Area Secretary
Nottinghamshire Area Ramblers

1st October 2025

**Great North Road Solar and Biodiversity Park
Application for a Development Consent Order (Application Reference: EN010162)**

Cumulative Applications Figure A2.1.1

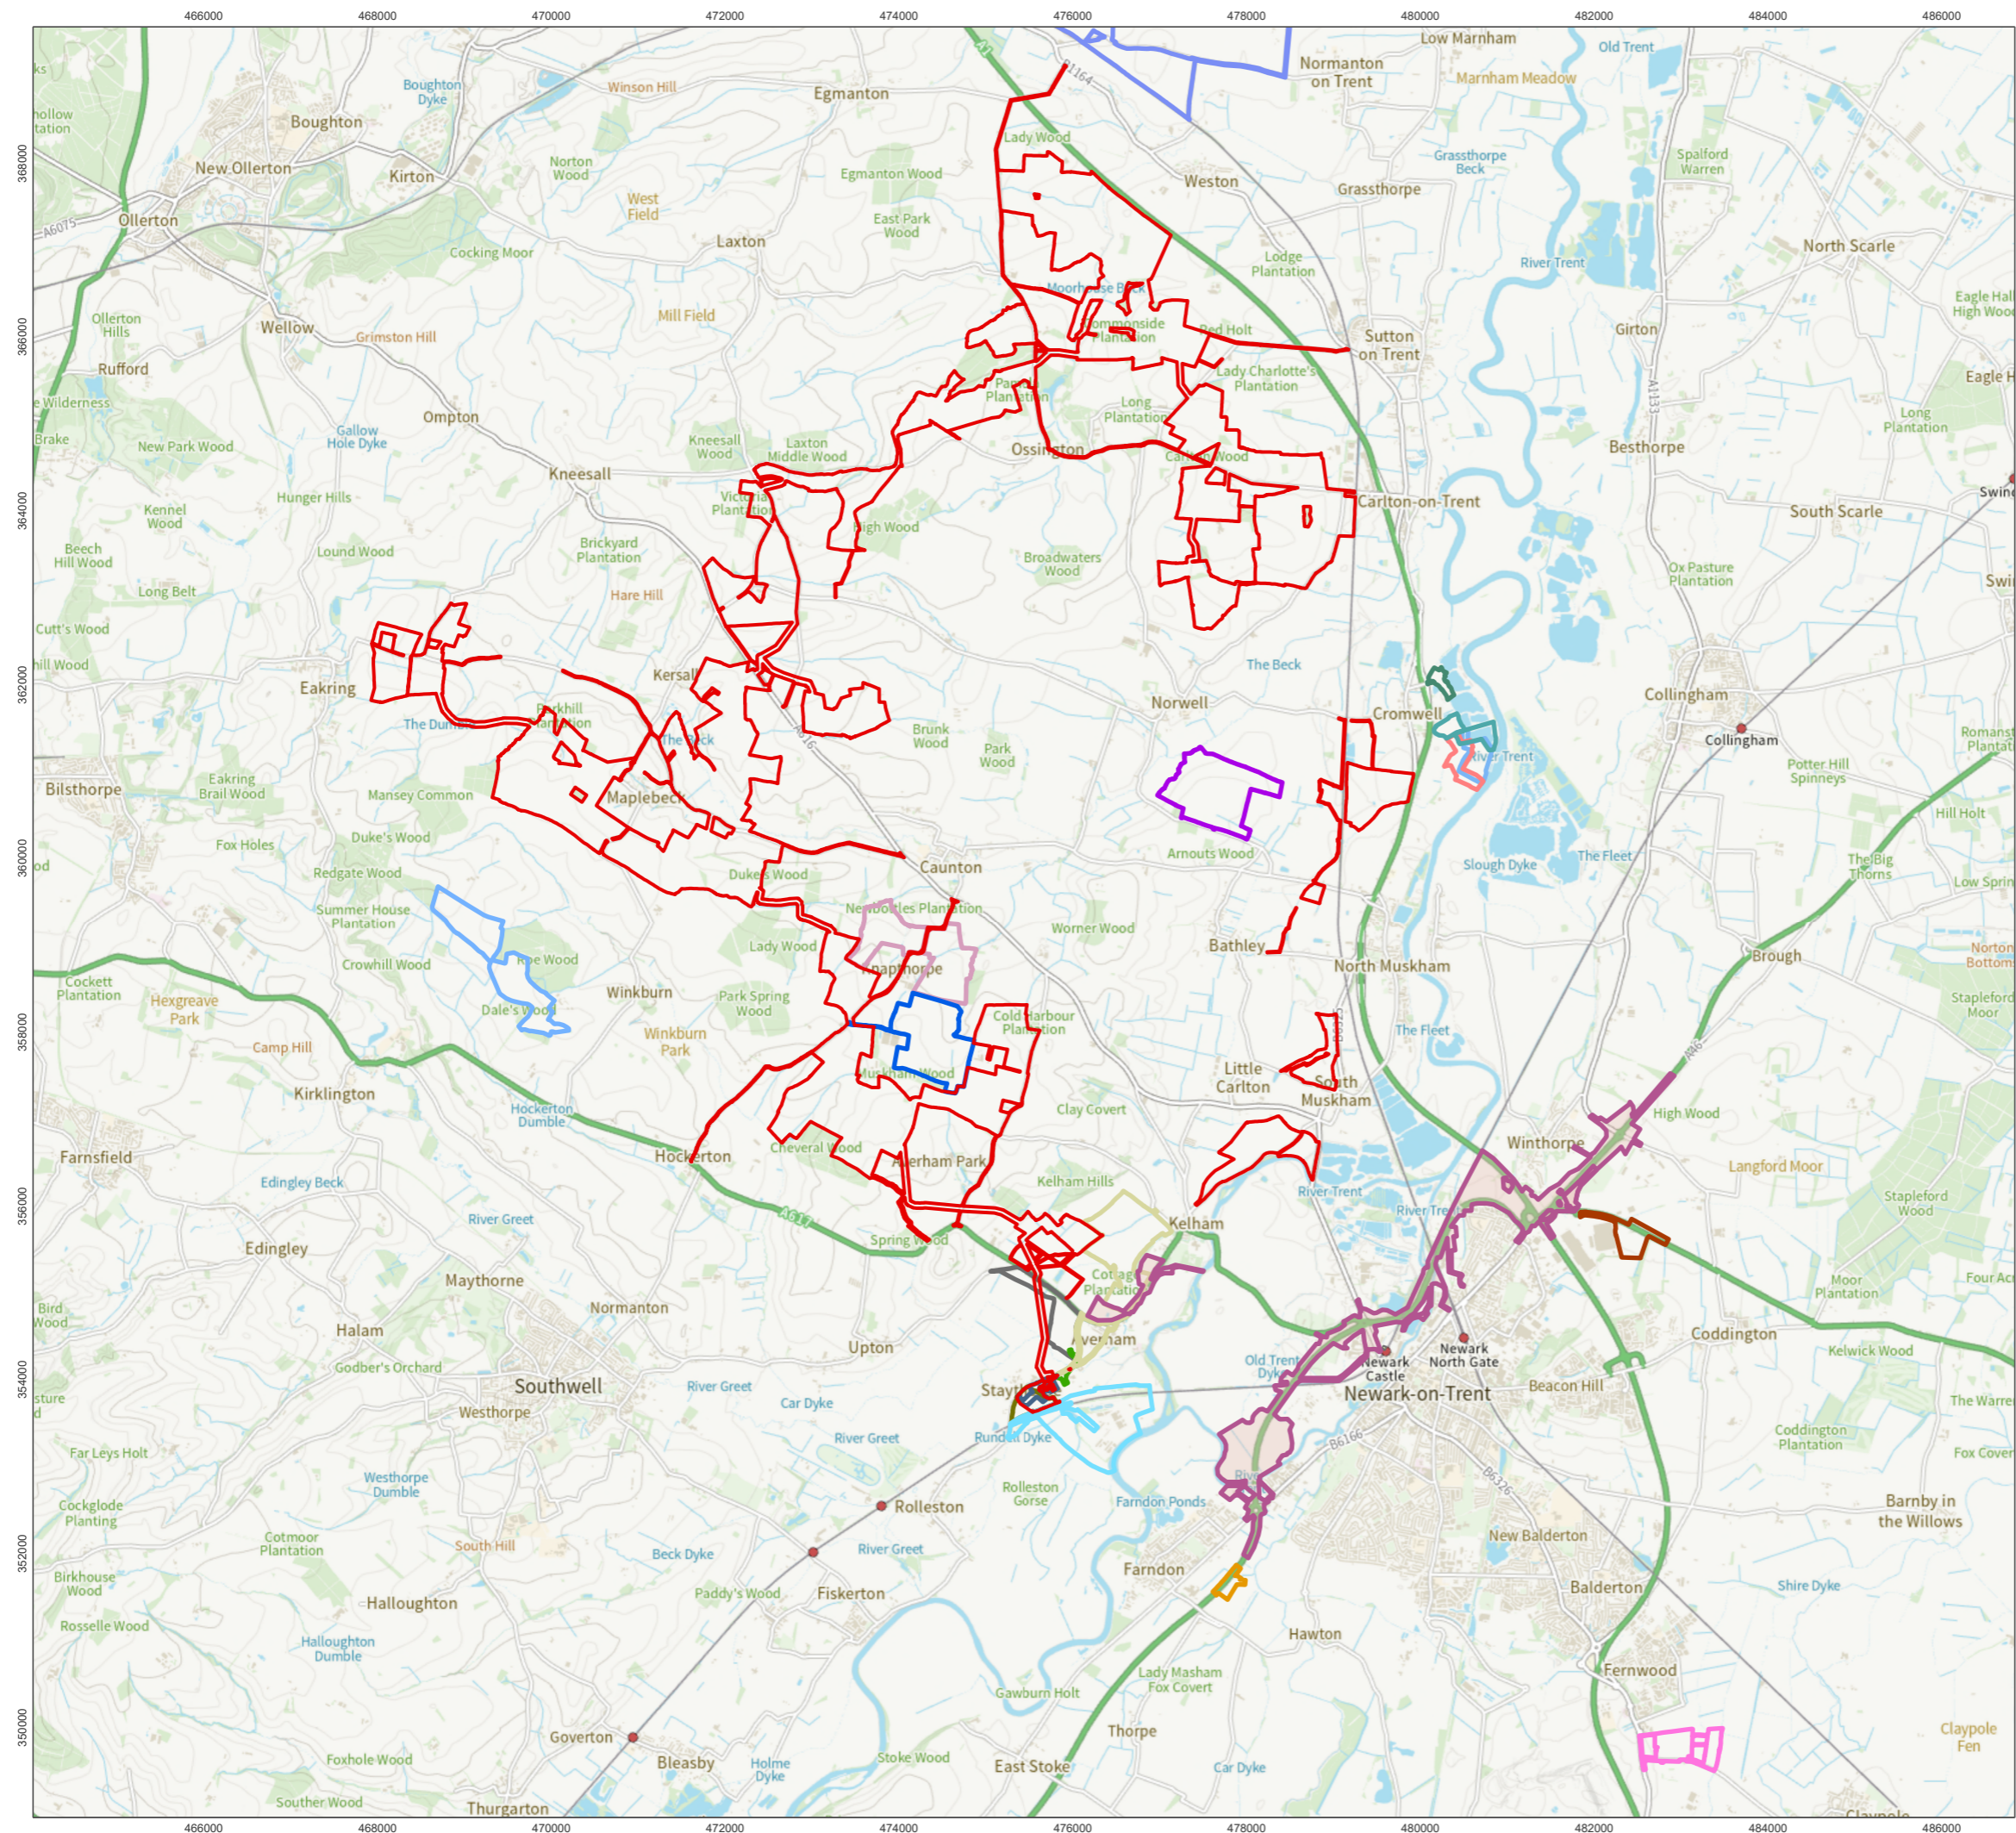
There appears to have been no assessment of the cumulative effect from the presence of a number of other solar farms that are in various stages of planning and implementation.

These schemes, if all of them become operational, will have a capacity of over 450MW, and cover around 1,970 acres pf the countryside. In other words, combined they are equivalent to more than 50% of the Great North Solar scheme. Of particular concern are several sites in the area around Cauntton, which, combined with Great North Solar will leave significant tracts of land covered in solar panels.

It is imperative that these sites are taken into consideration when considering the landscape effects of the Great North Road Solar and Biodiversity Park.
